## REITER ARCHITECTURE & DESIGN

**Subject:** Re: 227 York Street - details reviewed 4/25

Jeanie, as always, thank you for spending the time with me to go through some of the specific code interpretations regarding the proposed project at 227 York Street. Central to the discussion is the basic understanding that this is a residential R-3 building, but it is permitted to have a ground floor commercial occupancy within the building, by virtue of the lot's zoning. Per our telephone discussion today, I understand the following:

**S100**

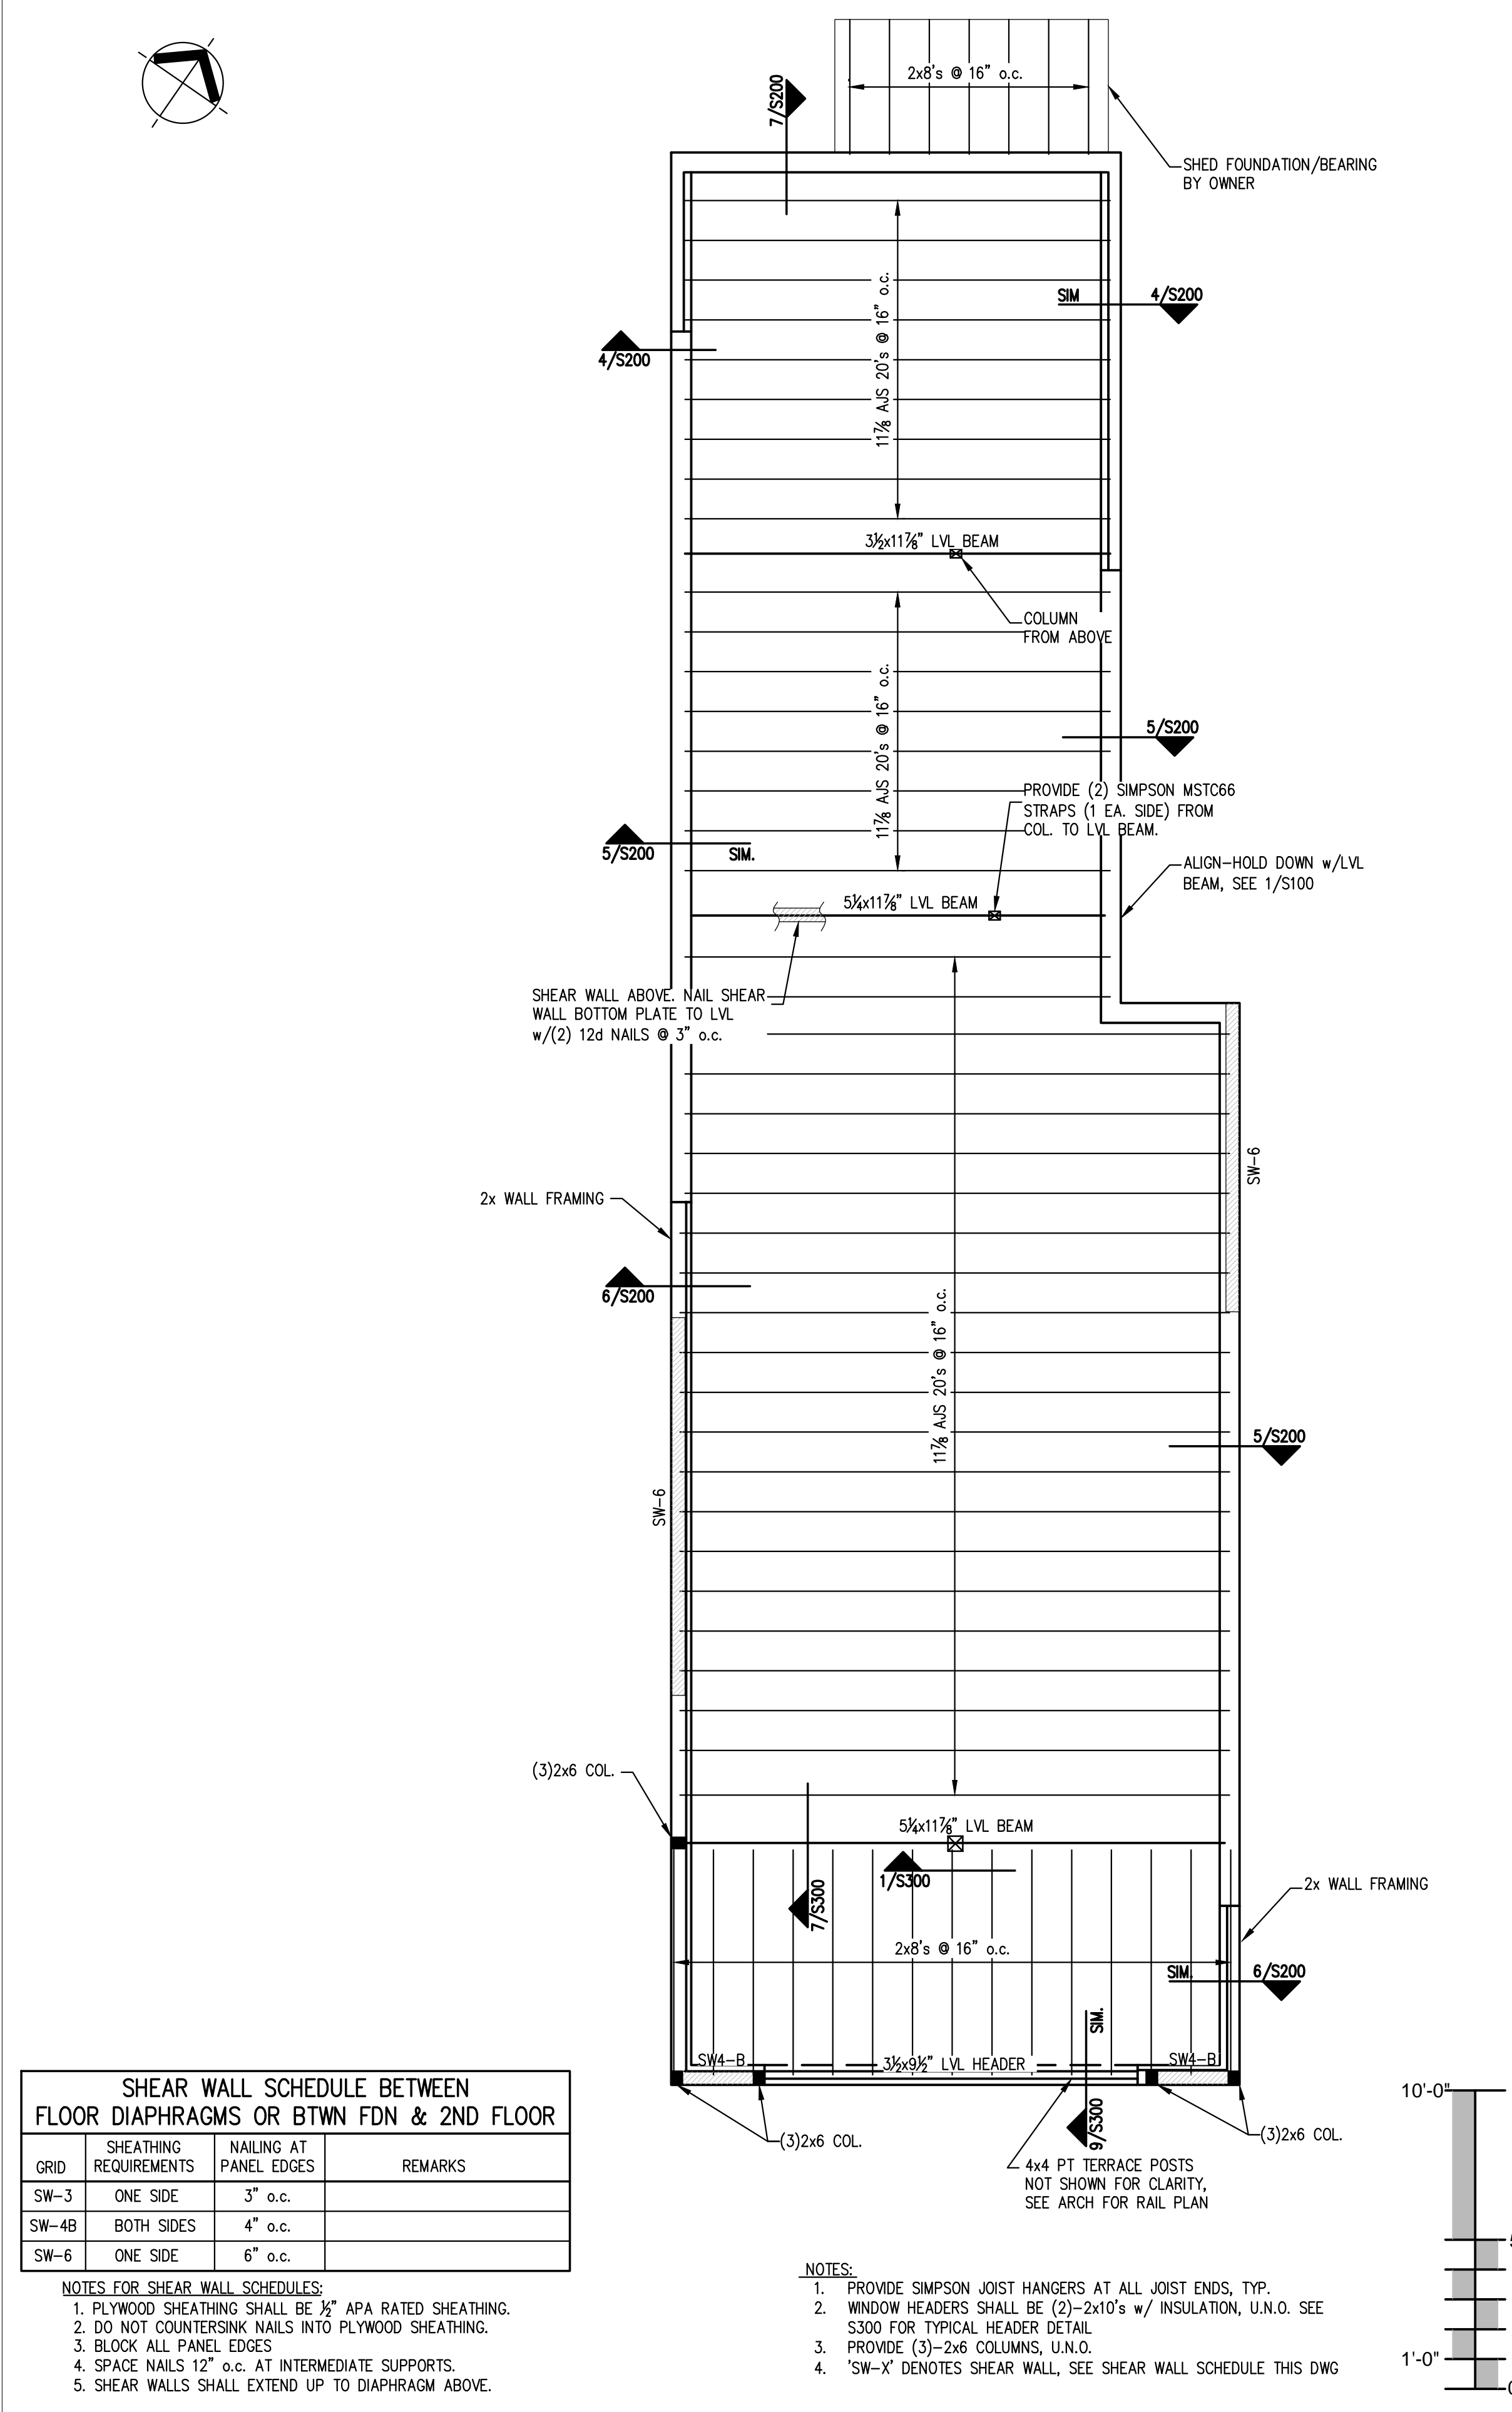
race area, and 11-7/8" TJI's at 24" o.c. underneath the first floor interior areas, with a consistent application of UL Design #L530 components. Acoustical insulation will also be included within the framing under the interior portion of the floor. **My only agreement here was for the change in framing components from LVL's to 2x8. The one hour fire separation is only allowed if the whole building has a full NFPA 13 system per Table 508.4 or if designed as mixed use, non-separated.**
